**KIRKLEES METROPOLITAN COUNCIL
INVESTMENT & REGENERATION SERVICE**

DELEGATED DECISION TO DETERMINE PLANNING APPLICATIONS

Reference No: 2018/62/90415/E

Description: Erection of rear extension on piers (within a
Conservation Area)

Drawing Title:  
**Proposed Ground and First  
Floor Plans**

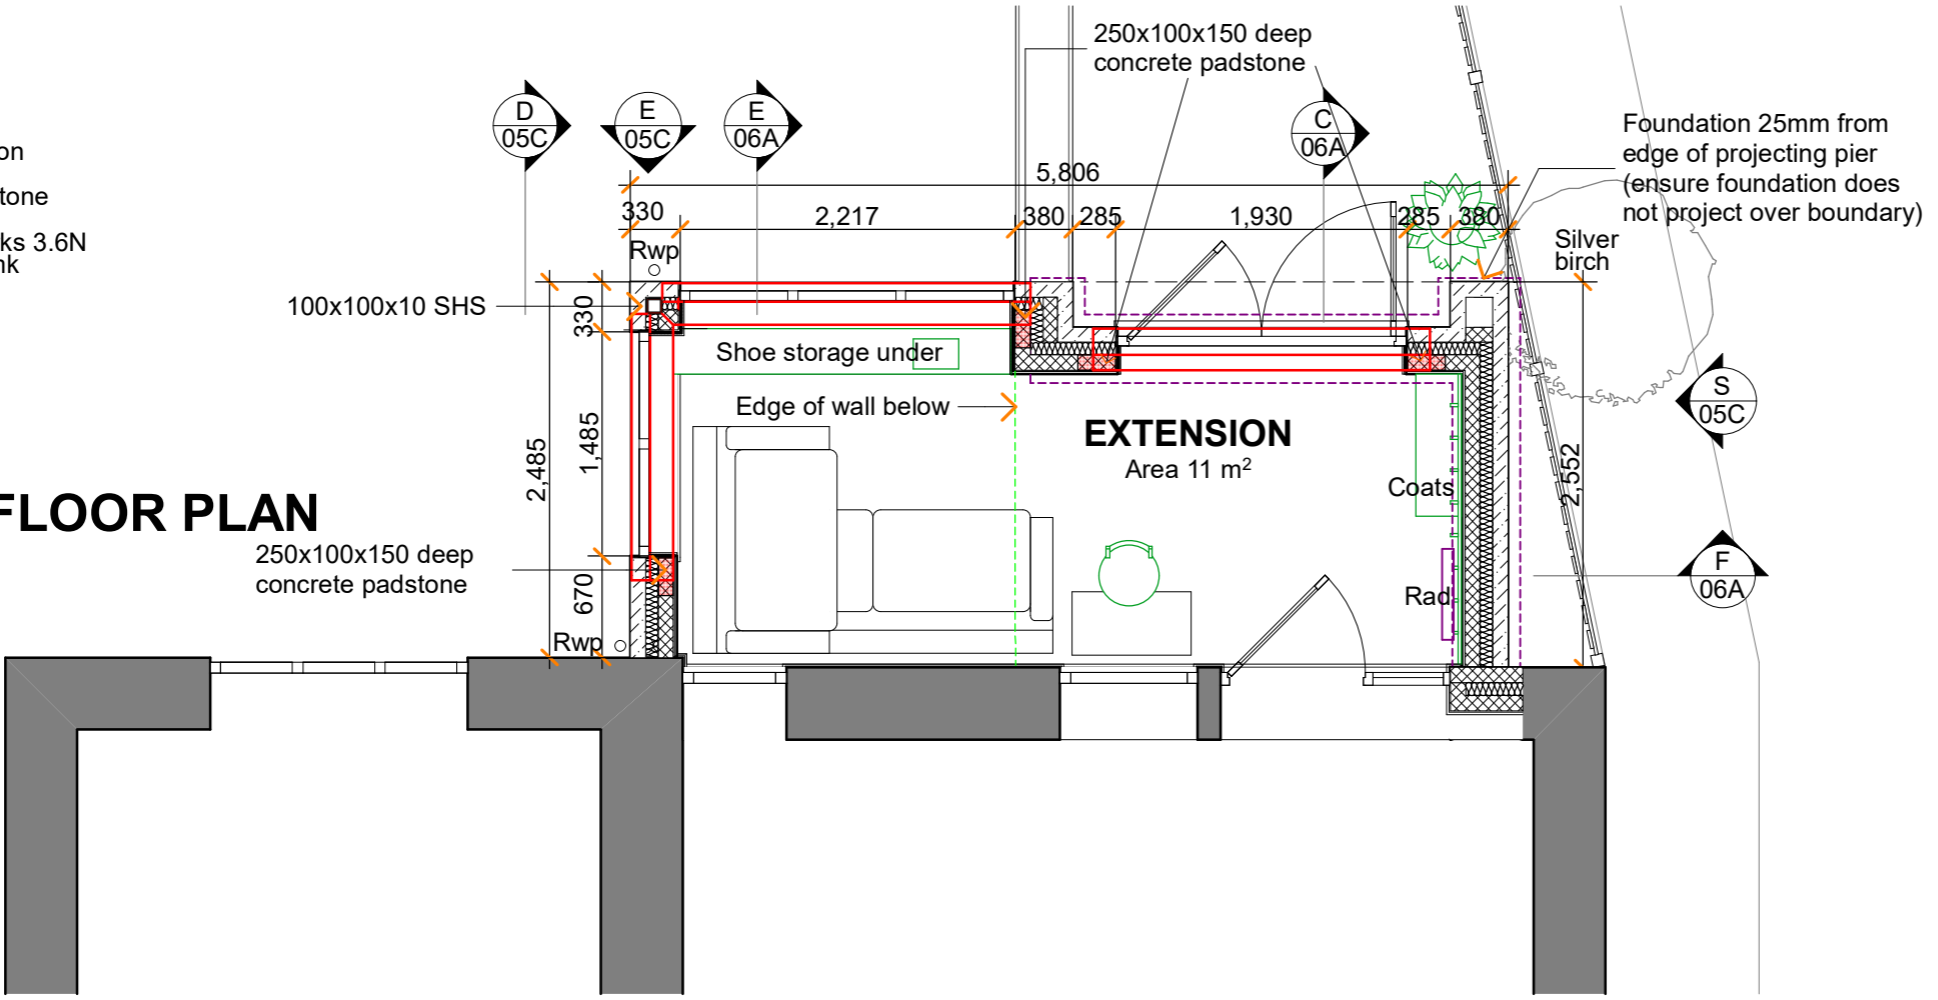
Although the width of the window proposed for the side elevation of the extension was reduced from the previously submitted plans, it was still considered that due to the size of the opening, that it would offer a significant amount of overlooking into the rear amenity space of the adjoining property. Amendments were sought from the agent to further reduce the size of the window in order to prevent overlooking into the rear amenity space of the adjoining property. Revised plans have been received which replace the original window with a high level window which will have a cill height of 1.68 metres. The window has been increased in width to allow additional light into the extension.

The case officer sought amendments to reduce the scale of the window proposed for the side elevation of the extension as it was considered that it could cause a significant amount of overlooking into the rear amenity space of the adjoining property. Amendments were received which replaced the originally proposed window with a high level window which will have a cill height of 1.68 metres.

4. Notwithstanding the provisions of section 55(2)(a)(ii) of the Town and Country Planning Act 1990 and the Town and Country Planning (General Permitted Development) Order 2015 (or any order revoking or re-enacting that Act or Order with or without modification) no new door or window openings other than those expressly authorised by this permission shall be constructed in the external walls of the north side elevation of the extension at any time without the prior written approval of the local planning authority.
